CITY OF ALBUQUERQUE

November 3, 2020

RE: 8500 Glendale Ave. NE
Grading and Drainage Plan (for Pool Building Permit)
Engineer's Stamp Date: 05/28/19
Hydrology File: B20D067

TITLE: 8500 Glendale
Grading & Drainage Plan

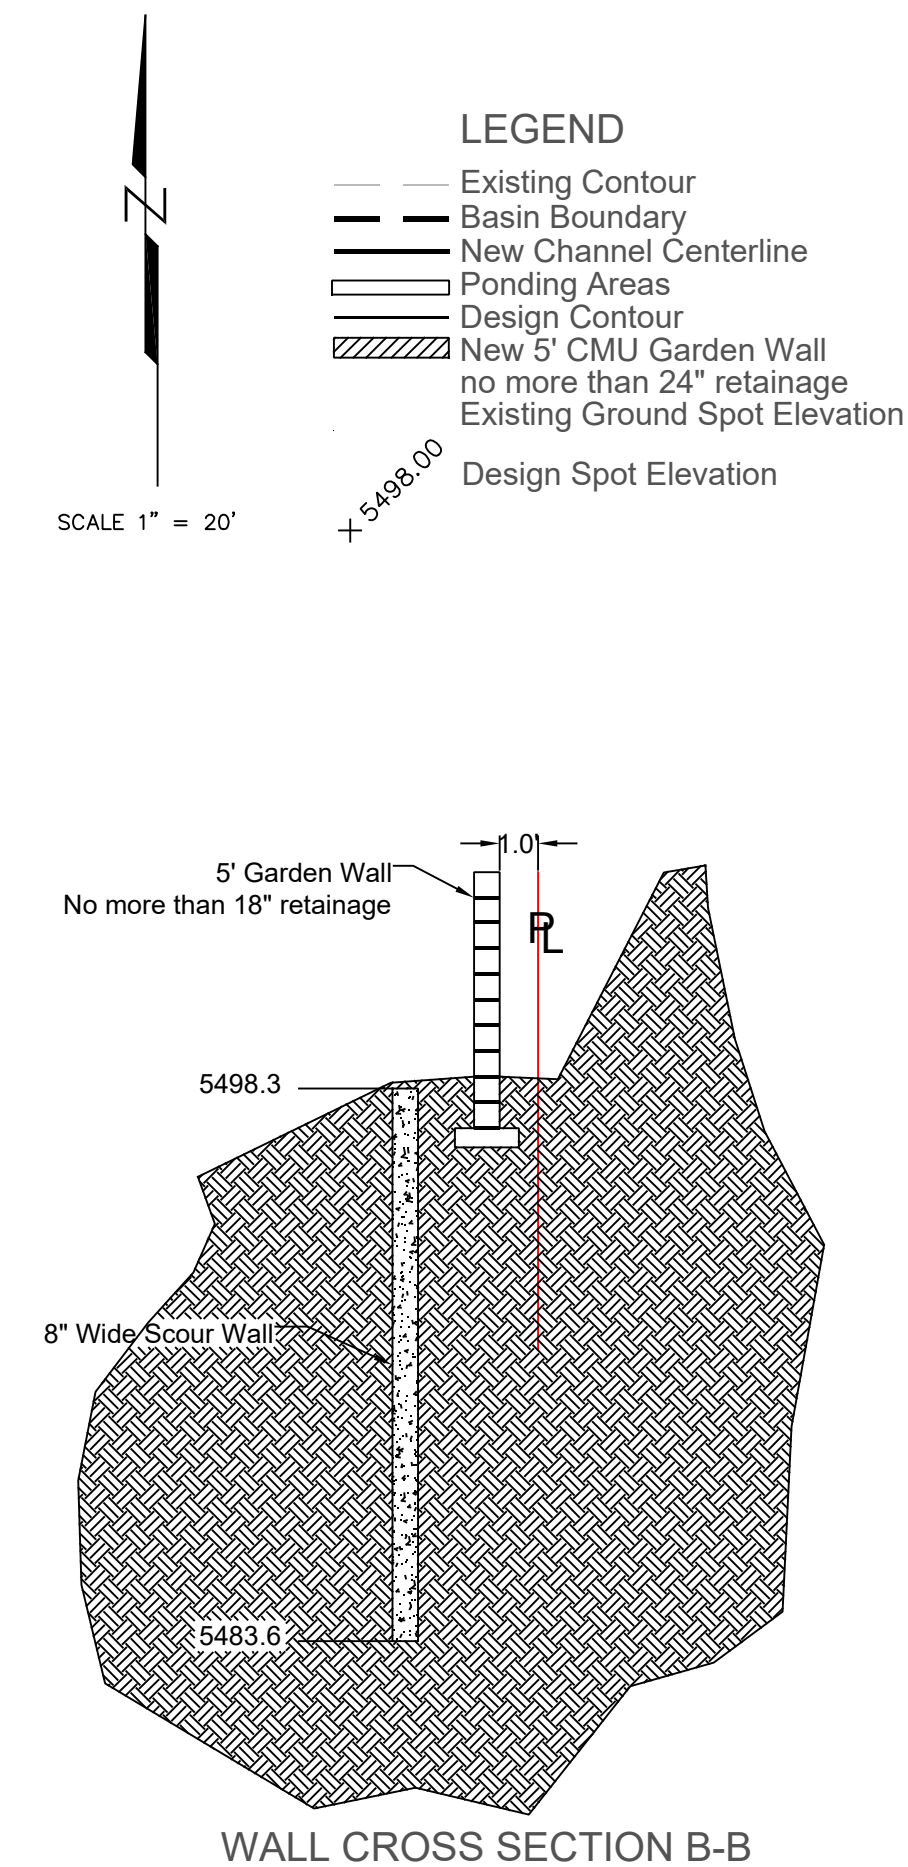
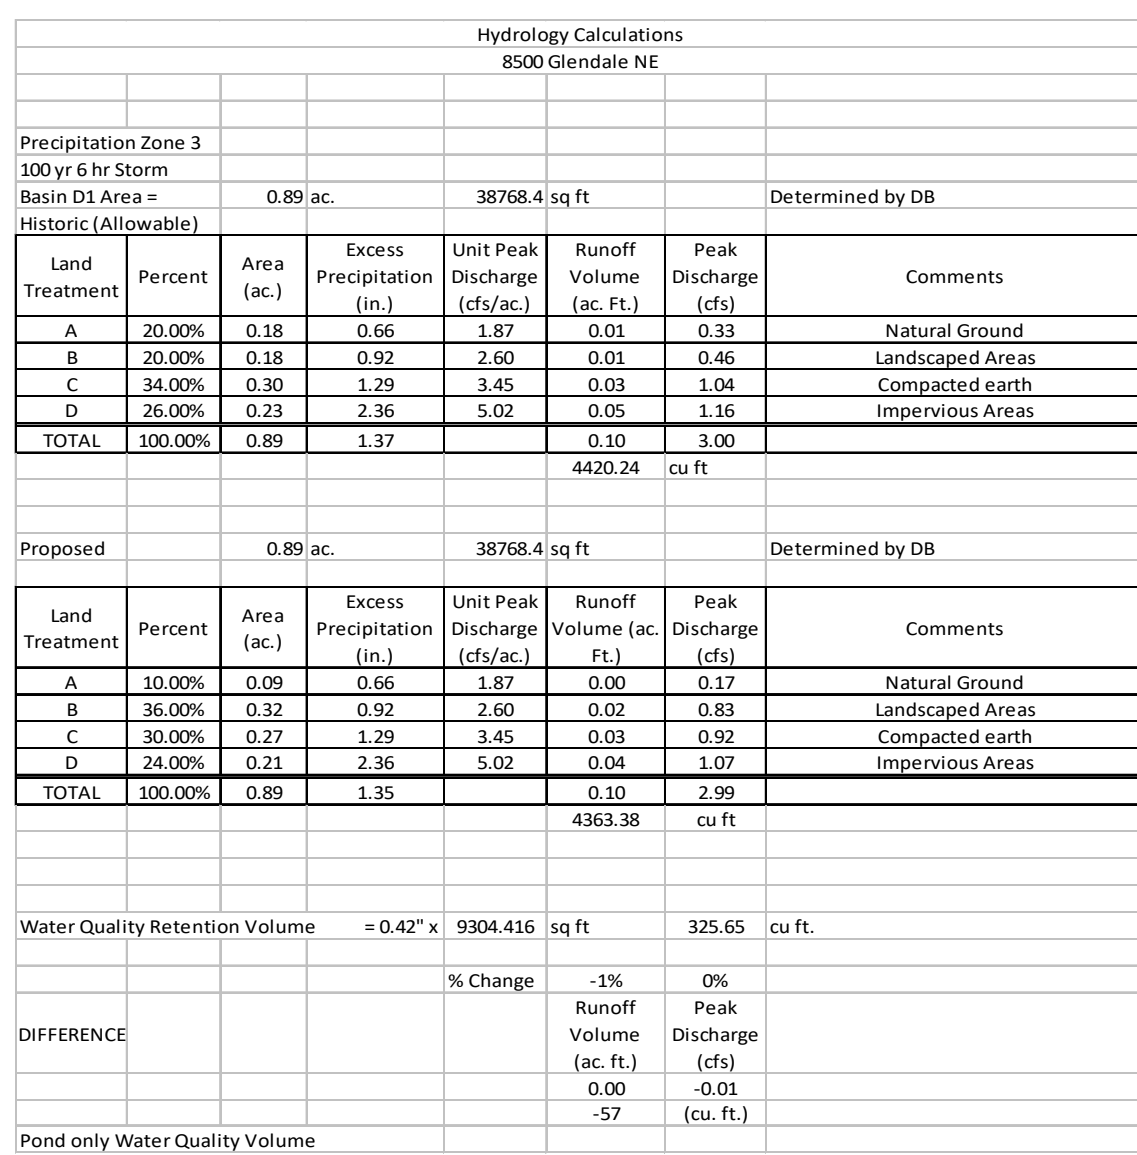
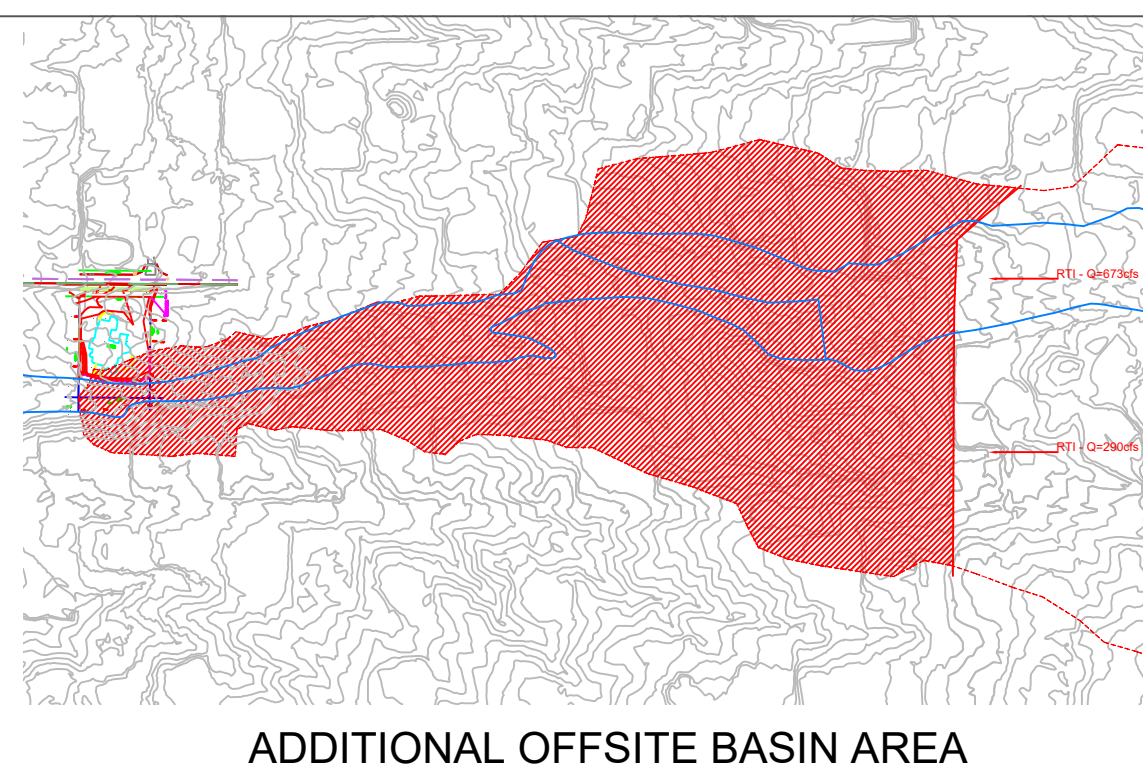
1. Please show the pool with concrete apron around the pool with grades of the corners of the apron.
2. Please provide dimensions to all structures.
3. I am concerned with the closeness of the corner of the pool with both the proposed garden wall and scour wall along the arroyo. Please provide a letter from either a geotechnical engineer or structural engineer with supporting calculations stating that the pool does not pose any structural concerns with either the garden wall or scour wall.
4. Please provide an updated Engineer's Stamp Date with the next submittal.
